From: Nelson, Jennifer L (DFW) <Jennifer.Nelson@dfw.wa.gov>
Sent: Friday, August 9, 2024 7:22 PM
To: Bradley Gasawski
Cc: Weekes, Cassandra L (DFW)
Subject: RE: SP-24-00009 Black - Notice of Application Memo

Cc: Jamey Ayling <jamey.ayling@co.kittitas.wa.us>; Bradley Gasawski <bradley.gasawski@co.kittitas.wa.us>; Chace Pedersen <chace.pedersen@co.kittitas.wa.us>; Zach Torrance-Smith <zach.torrancesmith@co.kittitas.wa.us>
Subject: SP-24-00009 Black - Notice of Application Memo

BLACK SHORT PLAT

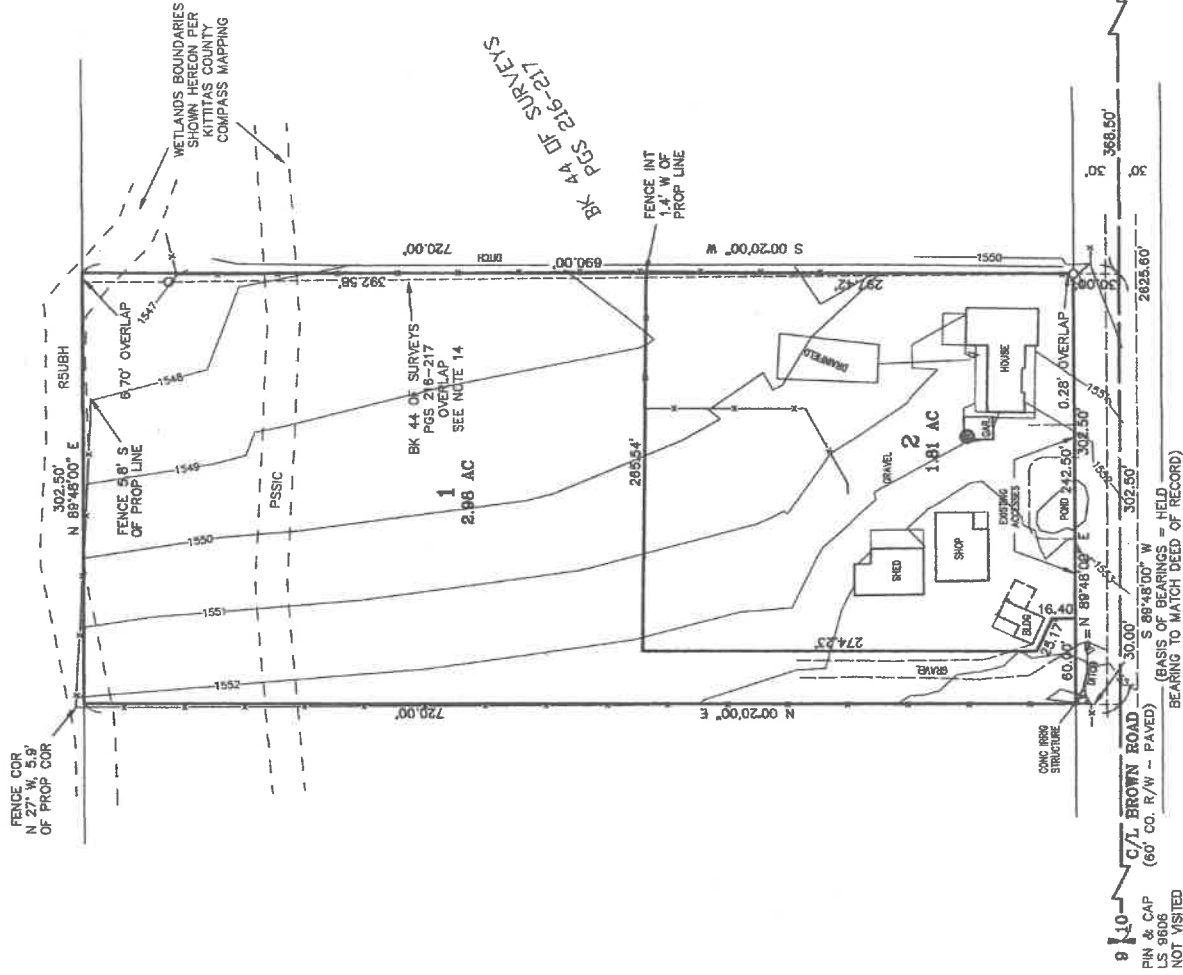
WDFW doesn't have many comments about this proposal, but the watercourse along the northern portion of this parcel appears to be an irrigation return. This feature is worth mentioning because of how entrenched it is and that it poses potential erosion concerns in the future. This feature also flows directly to the Yakima River, so ensuring good water quality in this watercourse helps ensure good water quality in the Yakima River and protection of aquatic life in the river. For this reason, we recommend future building setbacks treat this water feature with adequate riparian setbacks of at least 100 feet.
